WELWYN HATFIELD COUNCIL – DEVELOPMENT CONTROL
DELEGATED REPORT

APPLICATION No:	S6/2011/0833/FP
------------------------	------------------------

This application seeks full planning permission for the erection of a part two storey, part single storey side extension. The two storey side extension would measure approximately 8.6m in depth and up to 4m in width. The extension would project along the full length of the existing flank elevation and continue the ridge, eaves and pitch roof the main roof. A further single storey extension, measuring approximately 4m x 3m, would be situated to the rear of the proposed two storey element and adjoin an existing single storey rear projection. A replacement porch measuring approximately 1.9m x 1m is also proposed. The extensions would be finished in materials to match the existing dwelling.

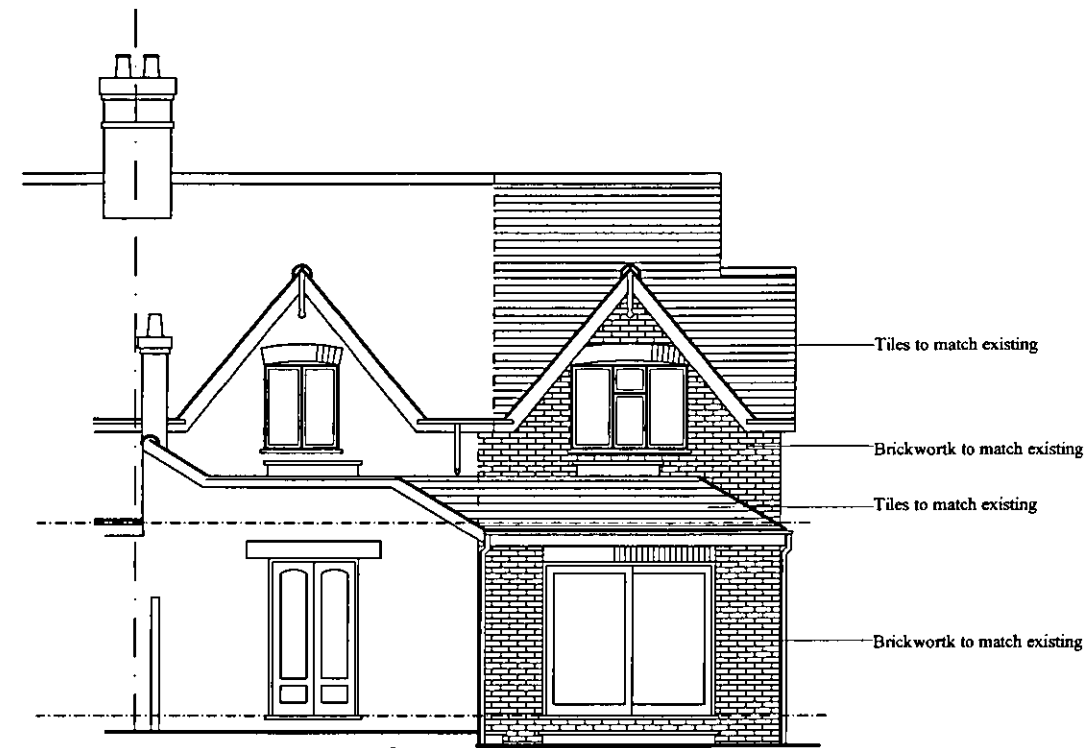
In terms of the effect of the extension on the openness of the Green Belt, the proposed increase in volume would materially increase the bulk and mass of the dwelling thereby reducing the openness of the Green Belt. Due to the orientation and the close proximity of the application dwelling to the highway at the side of the site, the two storey extension would be highly visible from viewpoints travelling along Shepherds Way. The increase in bulk and massing at a high level would result in more prominent structure than the existing dwelling and a reduction in the openness of its immediate surroundings. The proposed development would, therefore, have an adverse visual impact on the appearance of the surrounding countryside to the detriment of the openness, character and visual amenity of the Green Belt contrary to PPG2 and Policy RA3.

1. The proposed extensions would result in a disproportionate increase in the size of the original dwelling that would fail to appear as a limited extension to the dwelling. Furthermore, the proposed development as a result of its prominence, bulk and design would significantly diminish the openness of this part of the Green Belt to the detriment of the character of the area. The proposal is therefore inappropriate development within the Green Belt where the applicant has failed to prove to the satisfaction of the Local Planning Authority, that the harm, by reason of its inappropriateness is outweighed by other considerations contrary to the requirements of Policy RA3 of the Welwyn Hatfield District Plan 2005 and Planning Policy Guidance Note 2: Green Belts.

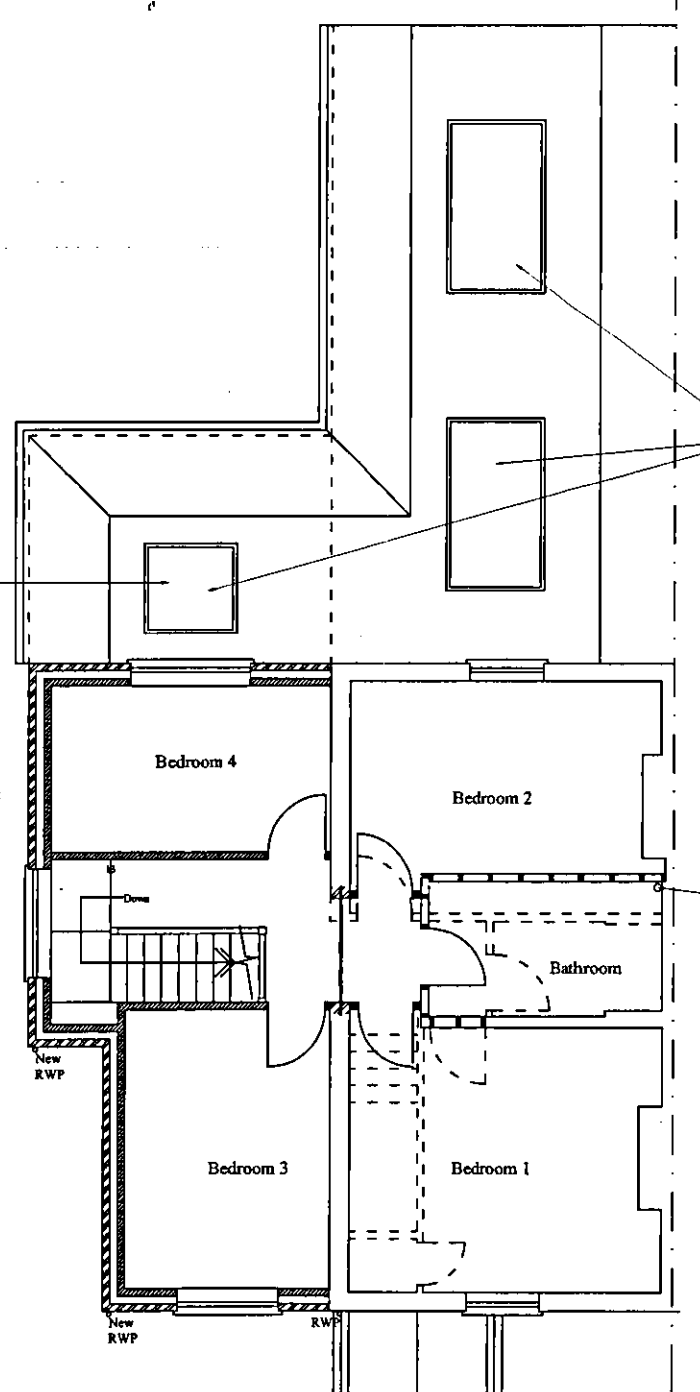
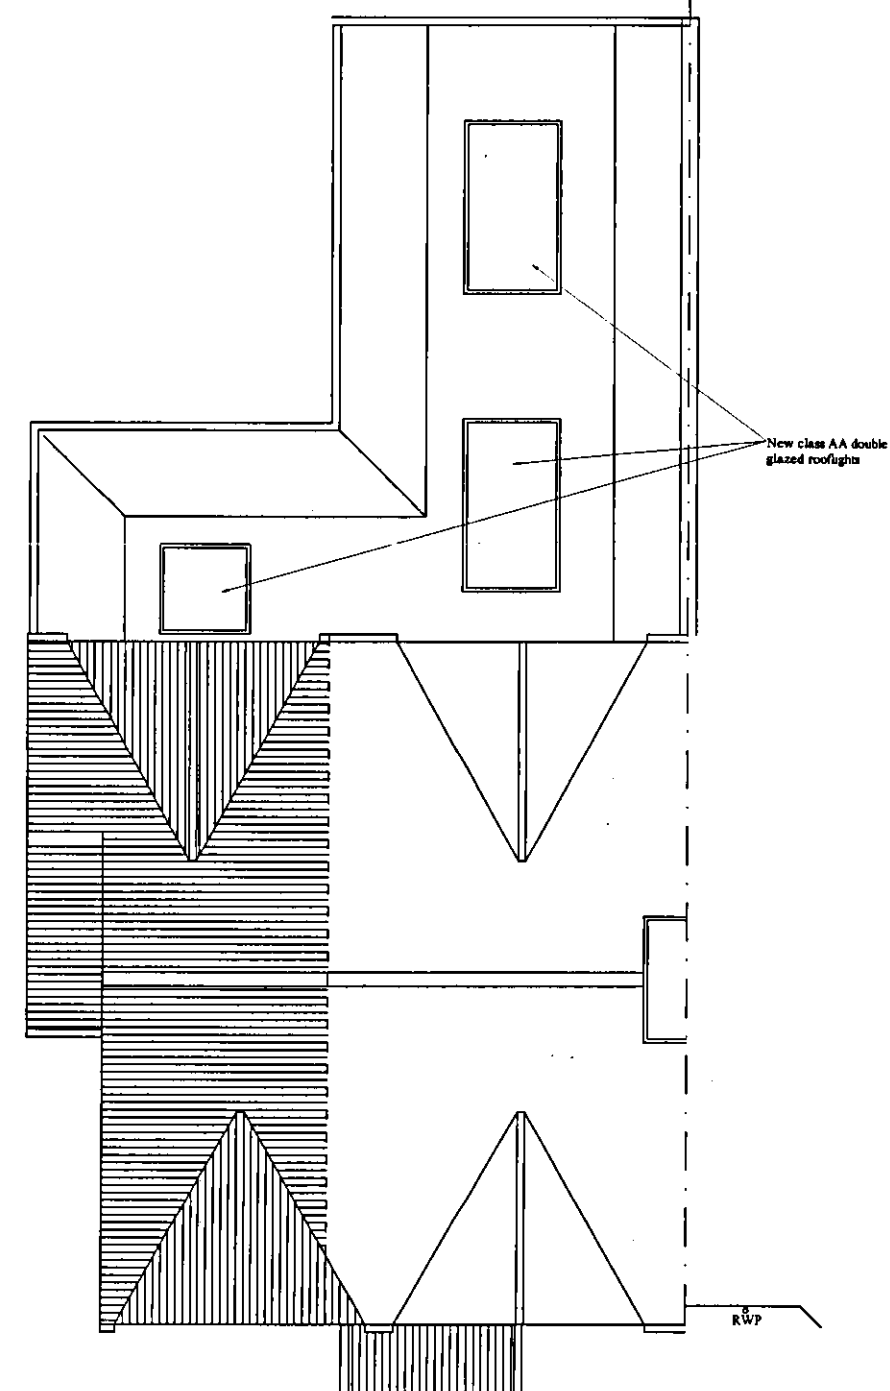
The proposed extensions would result in a total floorspace of approximately 193sqm which is equivalent to a 110 percent increase over the original dwelling. The footprint would increase to 123sqm which is equivalent to a 132 percent increase over the original dwelling (refer to historic drawings on this file). This level of increase is considered to be disproportionate. Furthermore, the increase in the height, cubic content and size of dwelling in comparison with the original dwelling, as a matter of fact and degree, would be considerable and substantial. Therefore, it is considered that the proposed extensions would amount to inappropriate development in the Green Belt.

The proposed development is likely to involve works to the existing roof structure of the application dwelling. The applicant has failed to demonstrate the development complies with the requirements of The Conservation of Habitats and Species Regulations 2010 9(5) as no appropriate bat survey has been submitted with the application to confirm whether bats are present in the existing roof of the application property. This is contrary to the requirements of Planning Policy Statement 1 (Delivering Sustainable Development), guidance contained in Planning Policy
